Planning Reference: P/124/21/HH

Location: 15, Greenways Pagham PO21 4QE

sheet 1 of 3

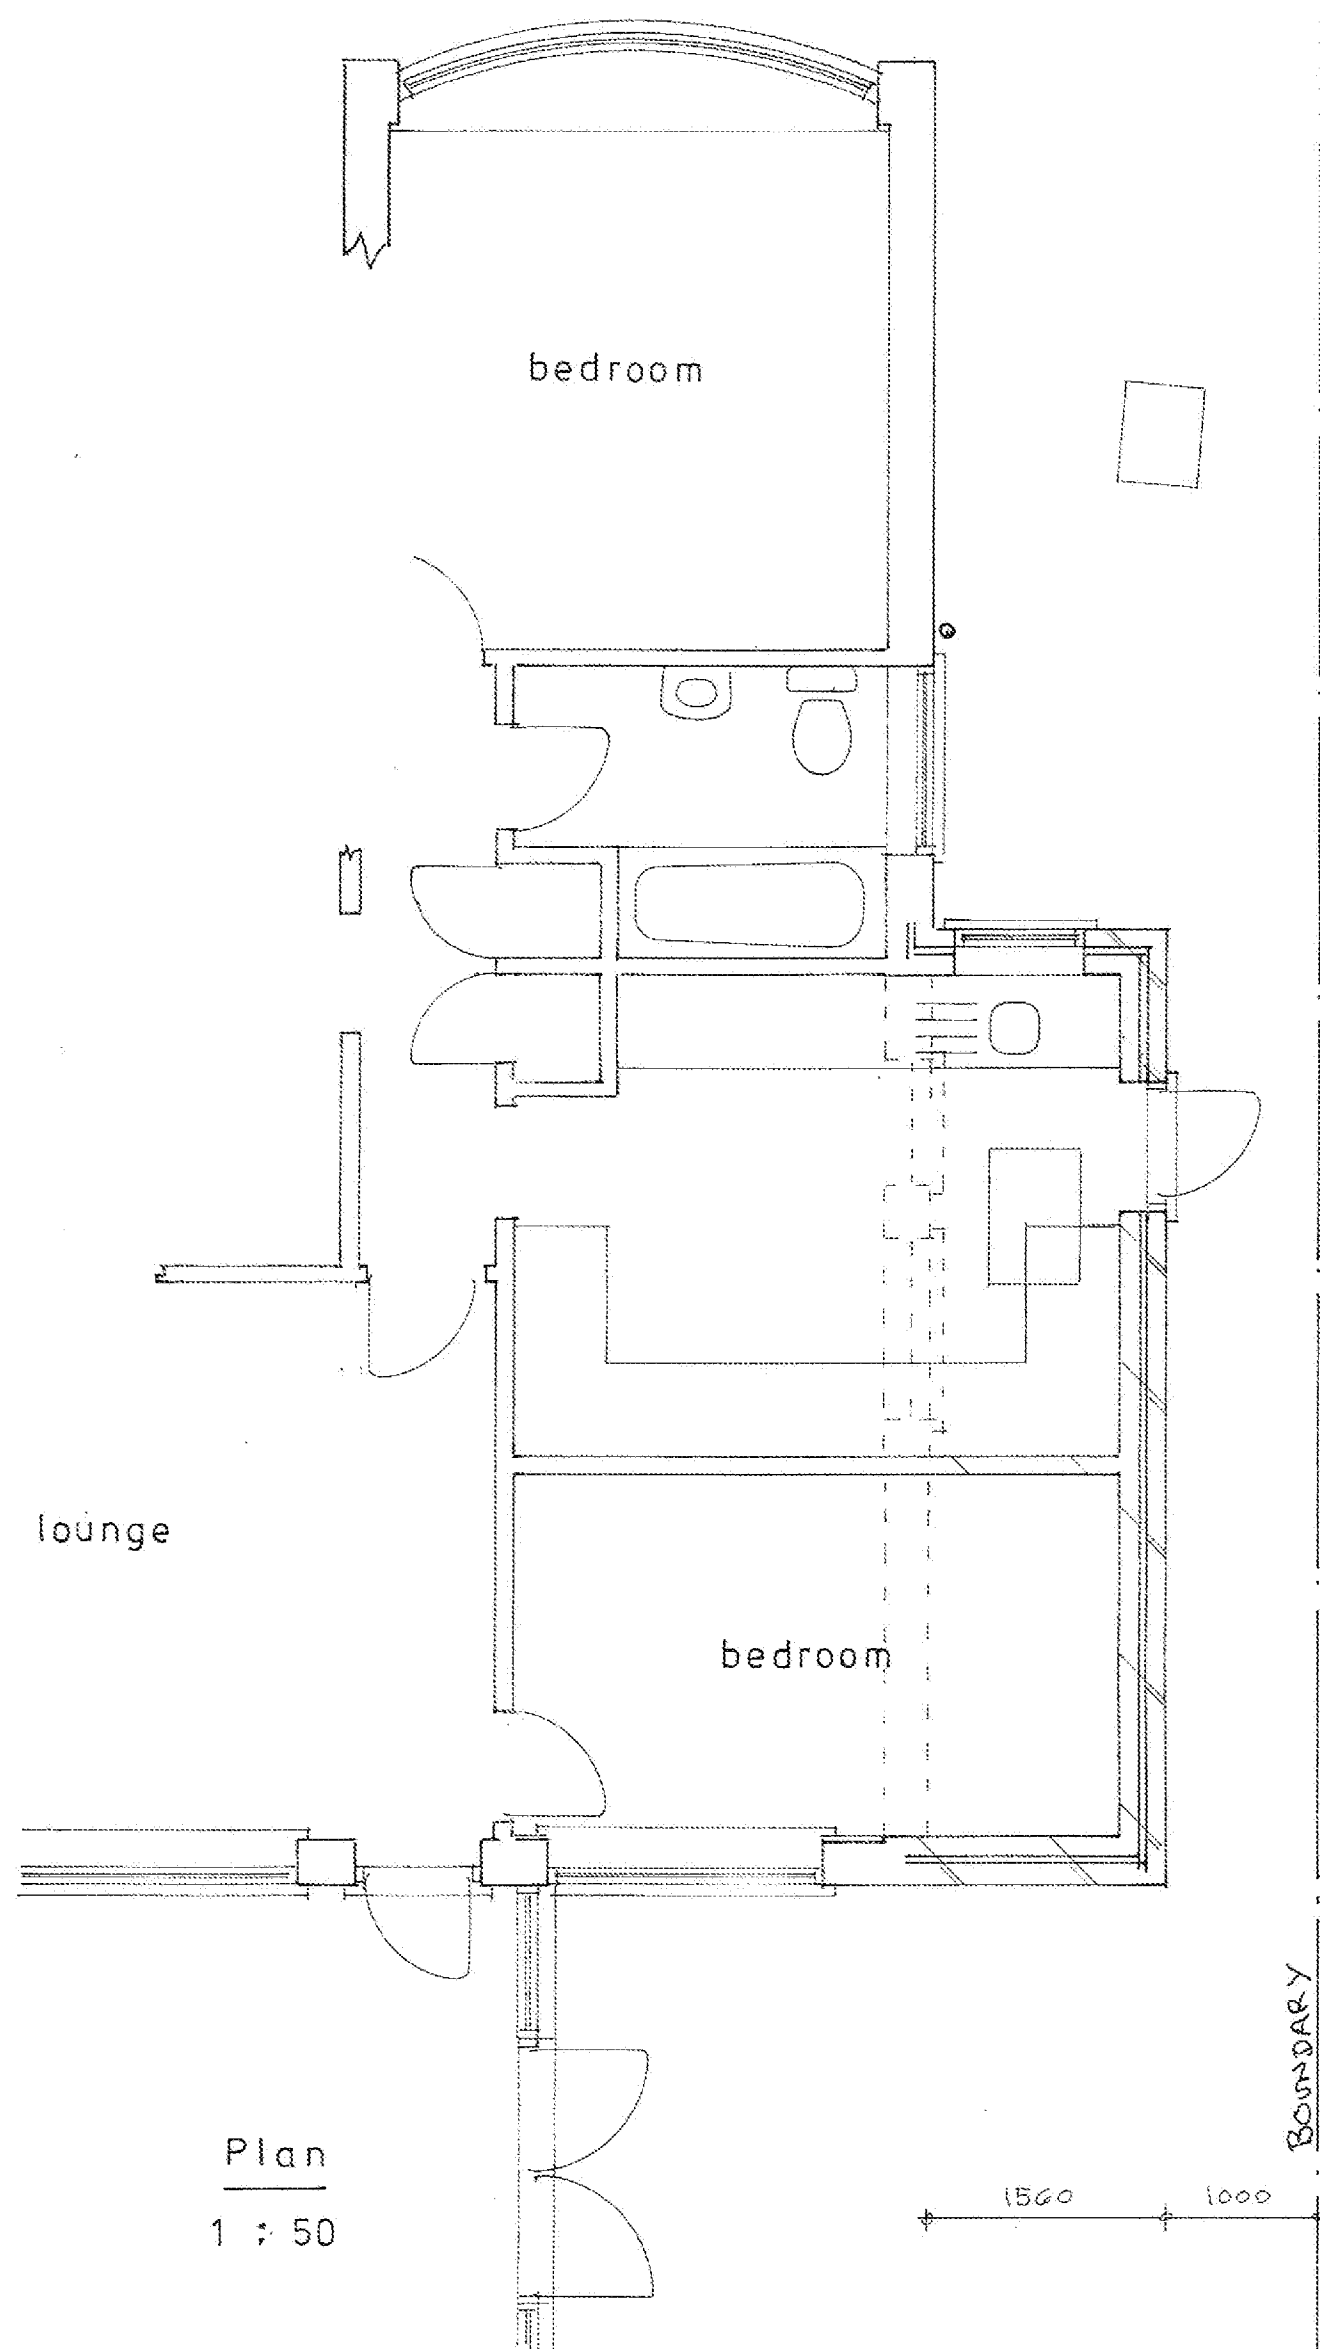
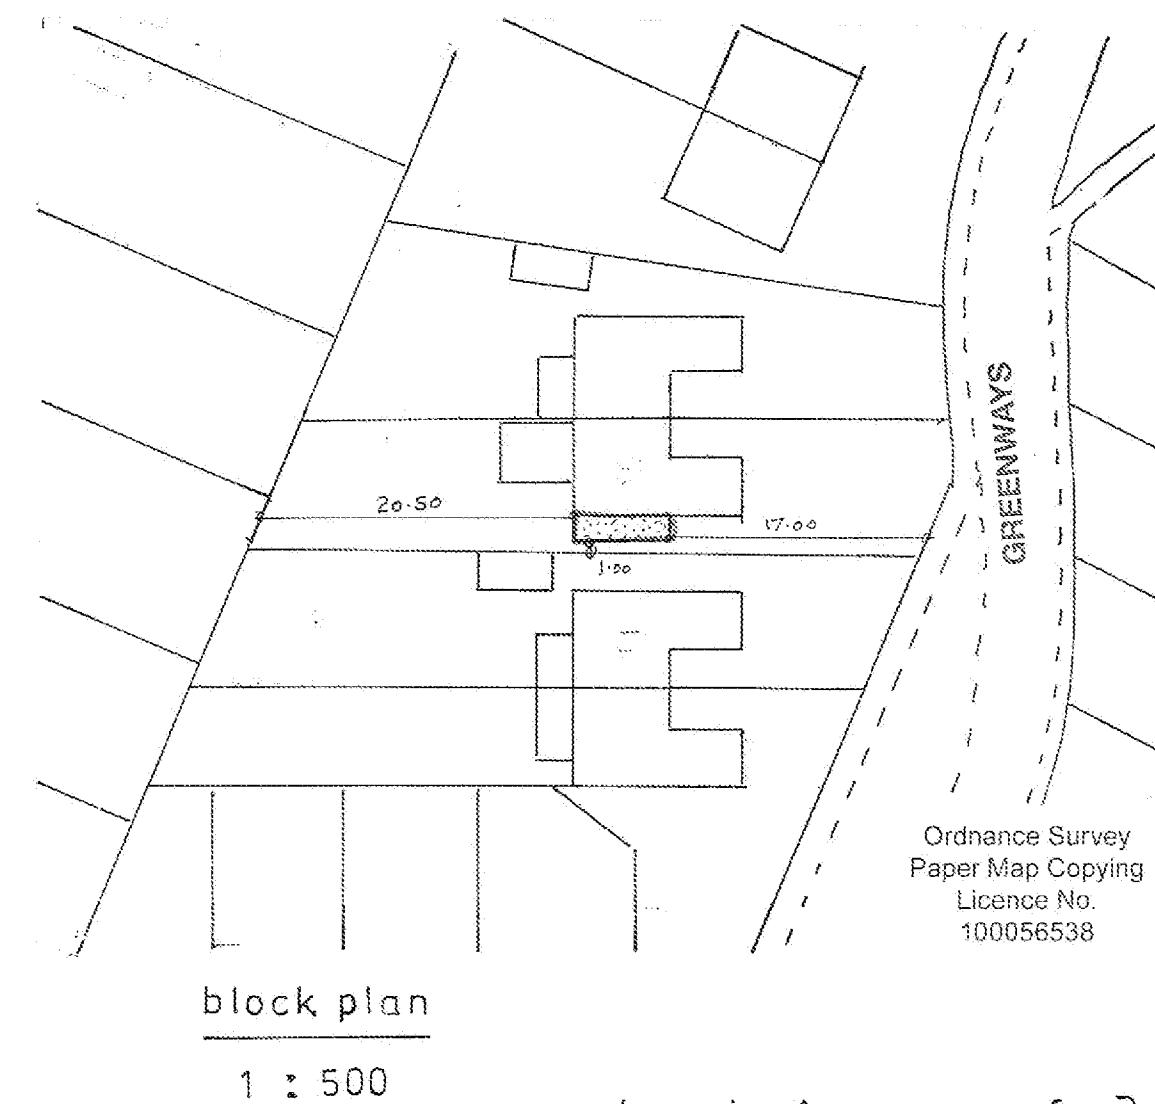
From examining the plans downloaded from Arun's website I can see that at least one of the pipes from my property will be severed by the excavation for the footings for this extension and probably all three – although I do not know the exact location of the pipes along the route they take underground it is likely that they travel in a straight line taking them under the ground that would be excavated.

I would ask therefore that this application be refused or at least delayed subject to the applicant providing the Council with detailed drawings showing the positioning of these pipes in relation to the proposed development. In the event that this development would sever these pipes then permission should be refused although the applicant could then submit modified scaled back plans that would not result in any damage to or interference with these pipes.

In addition to these waste/foul water pipes there are numerous other utility pipes/cables that are located beneath this sideway: the fresh water supply pipe; the electricity supply cable and the gas supply pipe. The plans submitted to the Council do not mention or

show the location of any of these pipes and this is of serious concern as there is potential danger of damage to property and loss of life here. In particular, should someone with a digger cut through the gas supply pipe then not only would they be killed in the resulting explosion but my property also would be seriously damaged and I could suffer serious injury or be killed in the explosion were I at home at the time. I would suggest that the applicant be therefore asked to supply the Council with detailed drawings showing the exact location of all these pipes/cables – I do know of people in Greenways who have in the past considered extending their properties into the sideways but have always abandoned the idea because of all the utility pipes and cables under the ground in this area.

Finally, and of less significance, I note from the plans that a door is proposed on the side of this extension close to the boundary with my property and it would appear that it will contain glass panels. As this would mean that my property could be overlooked I would ask that the Council stipulate that this glass should be opaque.
